M60/M62/M66 Simister Island – TR010064

Section 51 advice regarding draft application documents submitted by National Highways

The advice recorded in the table below relates solely to matters raised upon the Planning Inspectorate's review of the draft application documents listed above. The advice is limited by the maturity of the documentation provided by the Applicant and the time available for consideration and is raised without prejudice to the acceptance decision or the final decision about whether development consent should be granted.

FIGURE 2.3

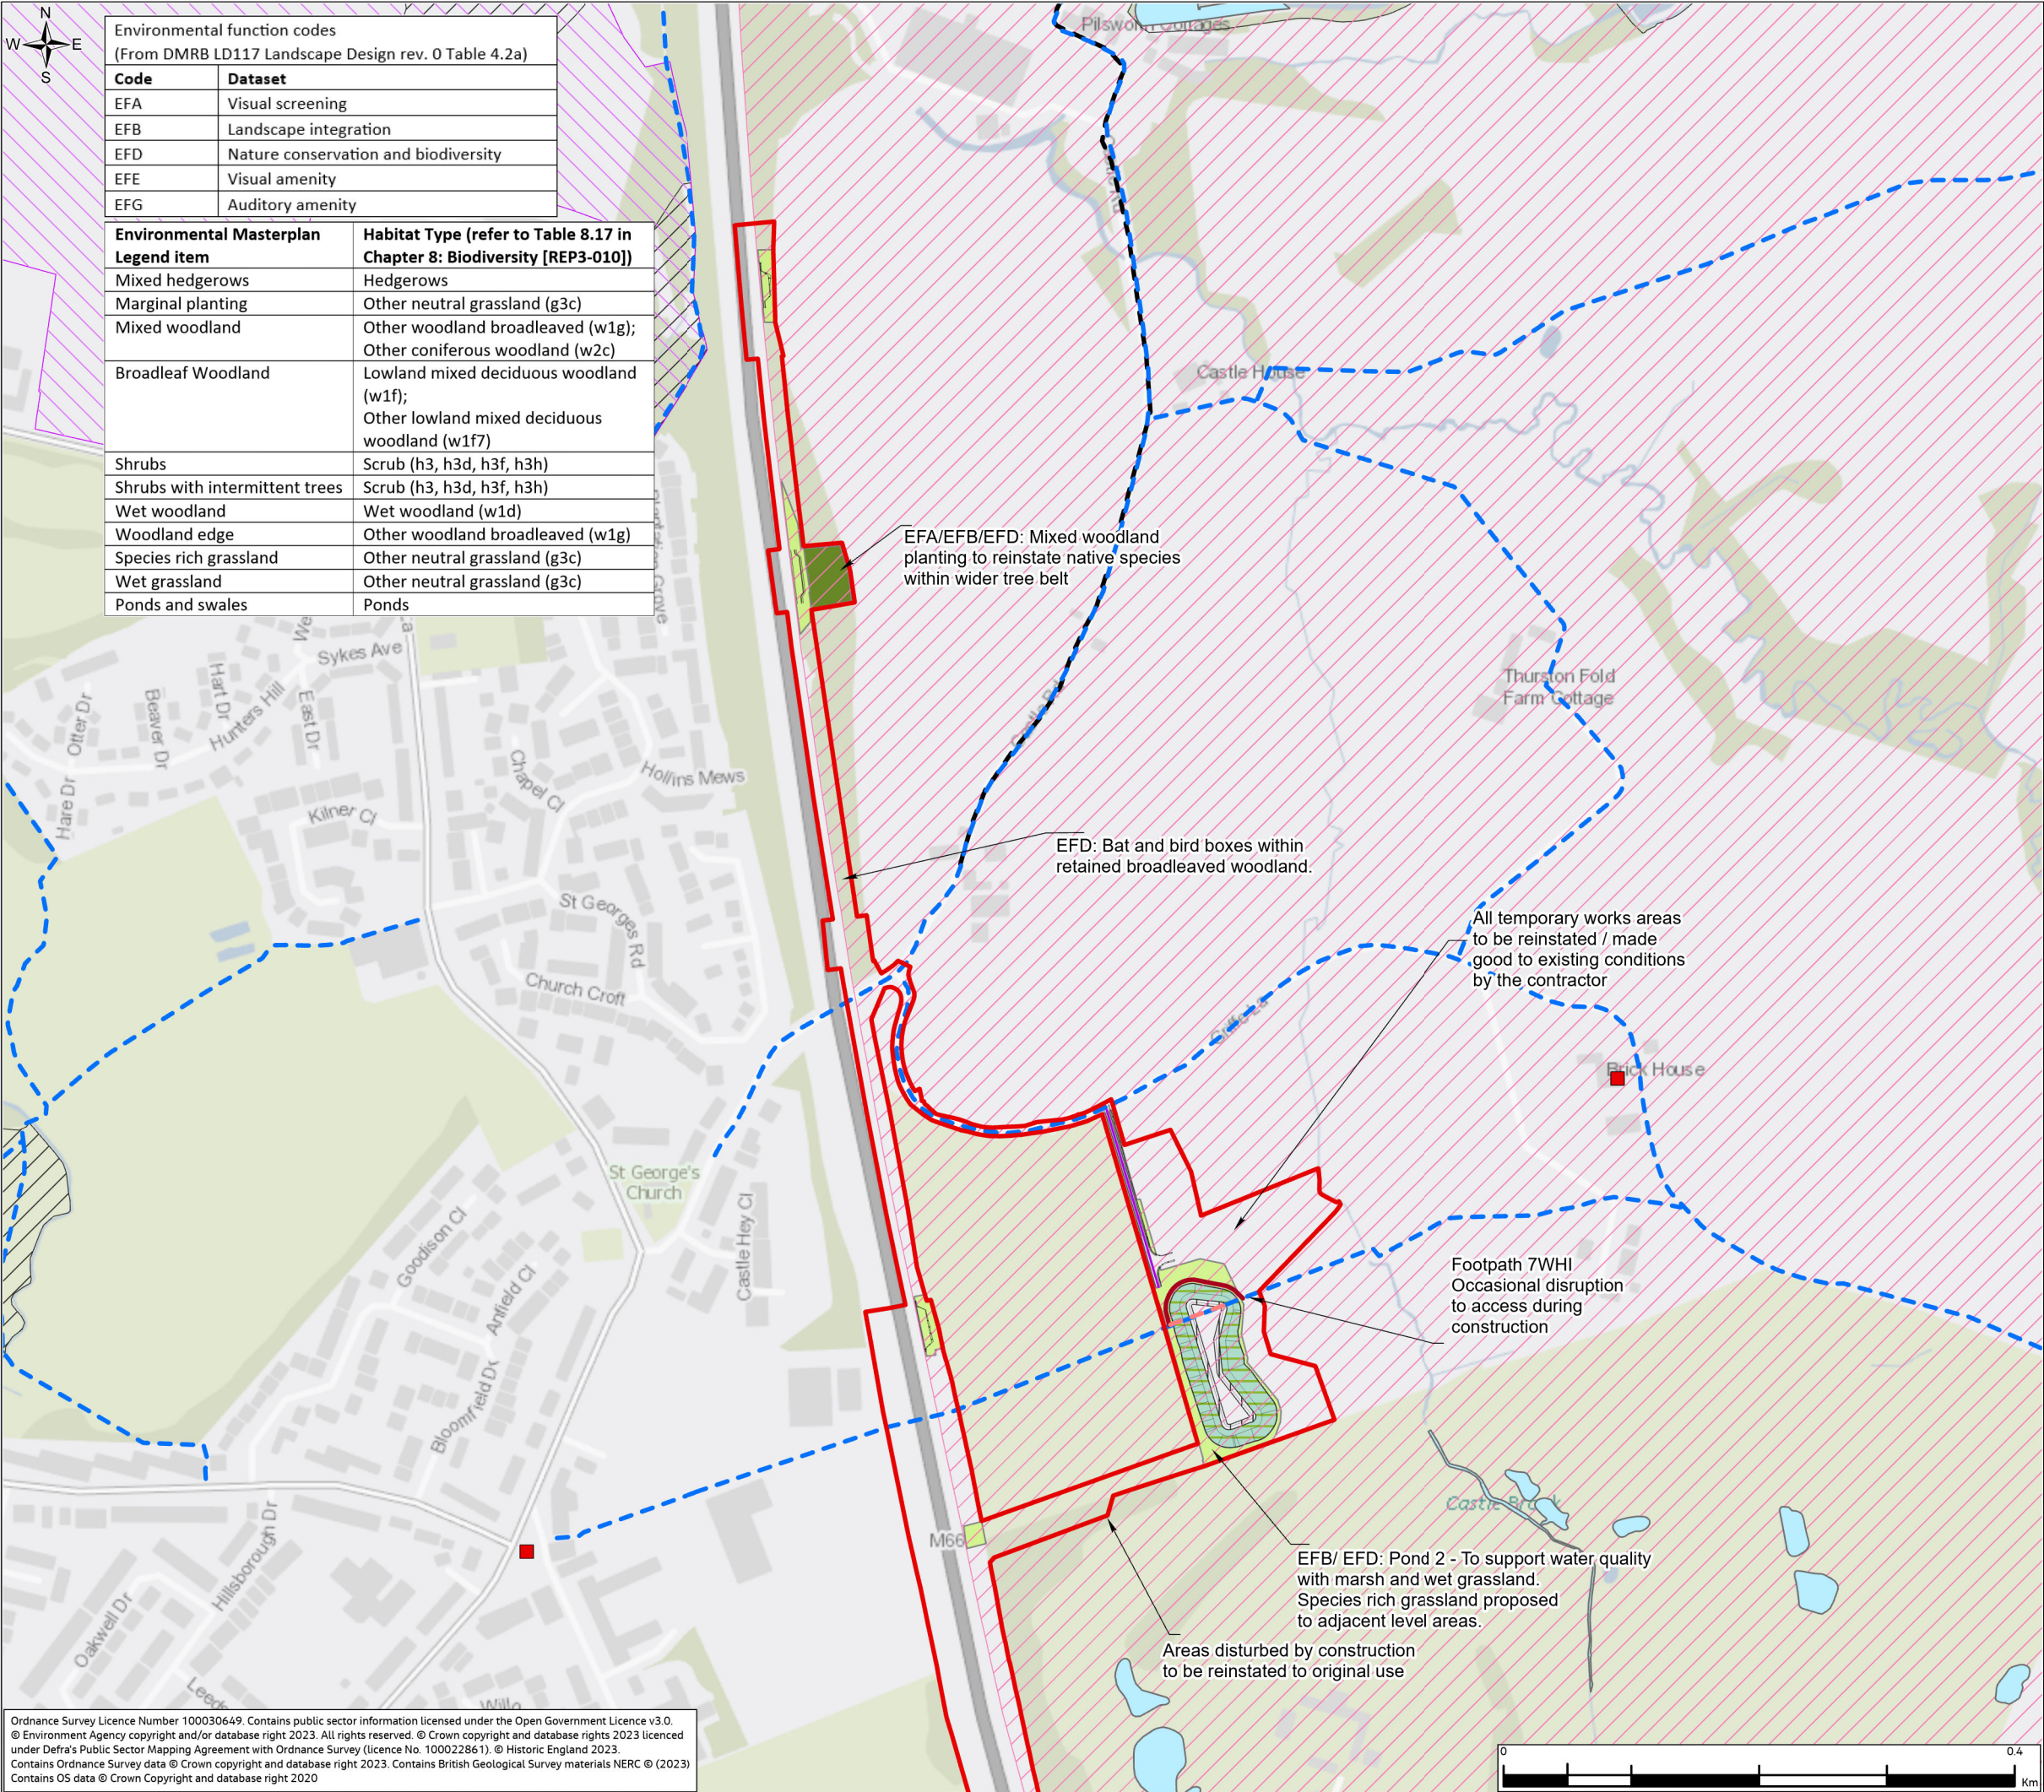
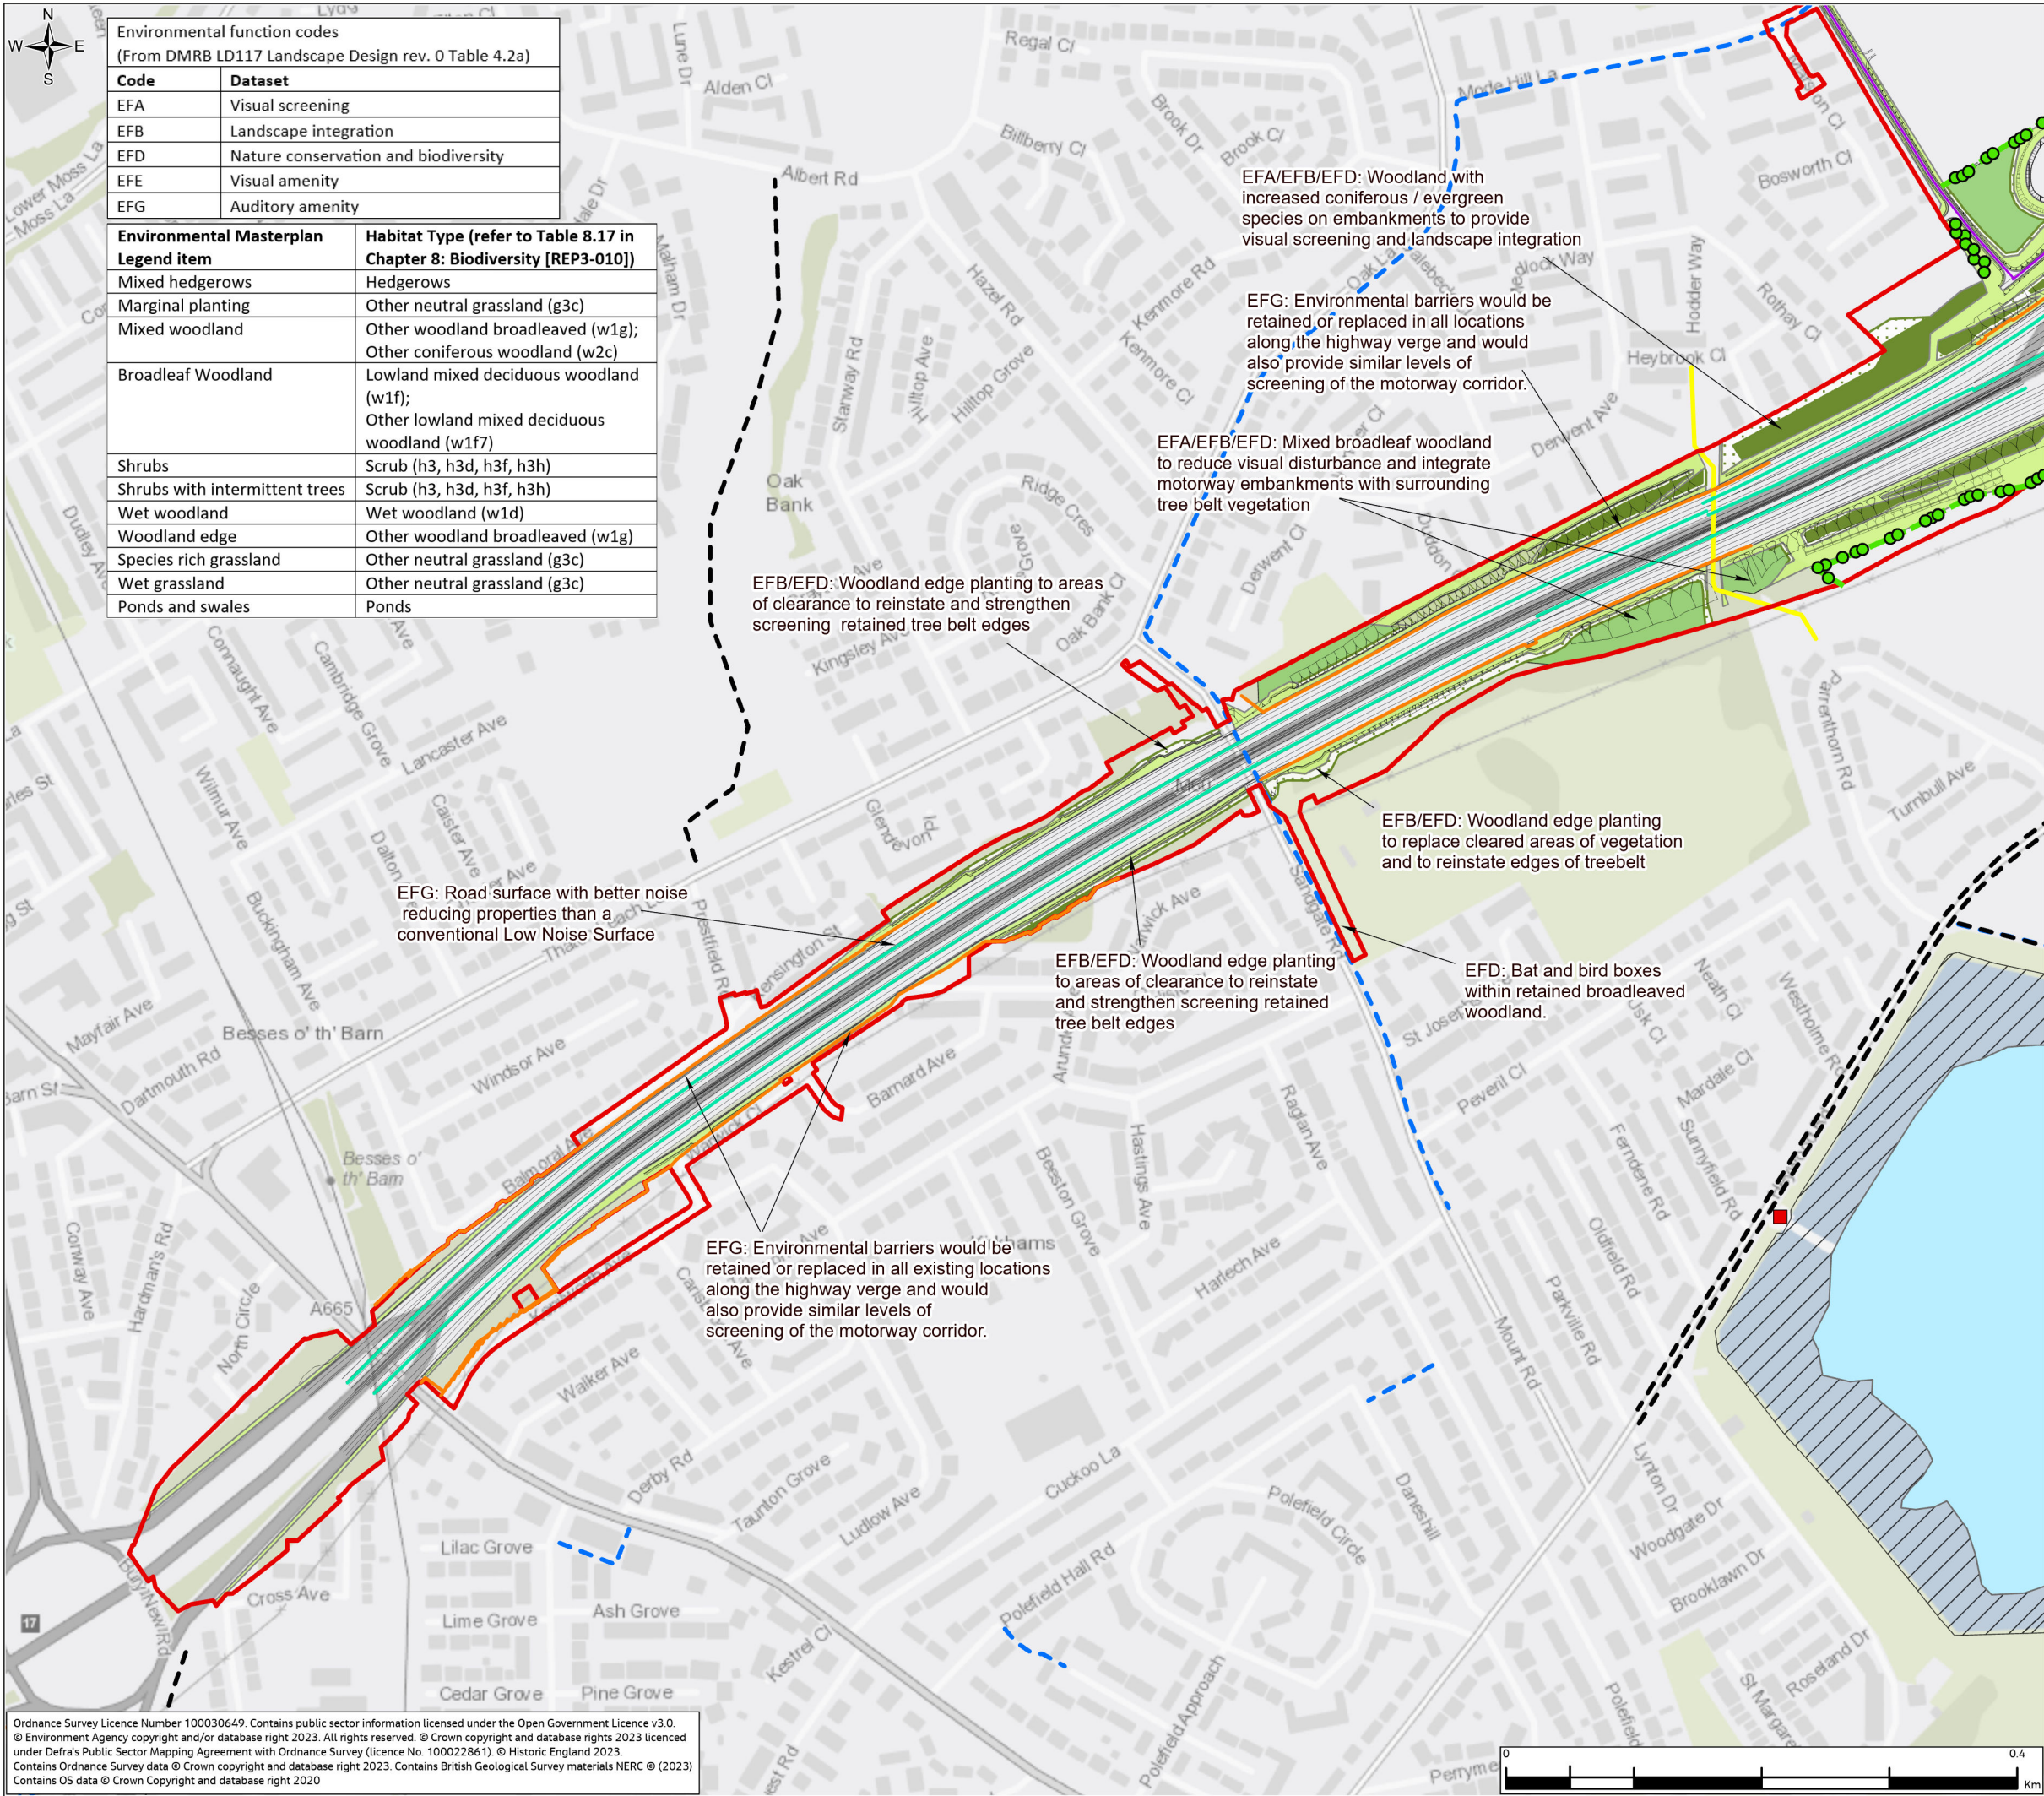
Environmental Statement Figure 2.3 Environmental masterplan		
Ref No.	Paragraph/Section	Comment/Question
26.	Figure 2.3	The legend shows a typography for a 'Public Right of Way' (PRoW), a 'Restricted byway' (sheet 1) and 'Bridleway/bridlepath' (sheet 5). Restricted byways and bridleways are both types of PRoW but it is not clear why these two categories are differentiated. It is suggested that the Applicant distinguishes between all types of PRoW.
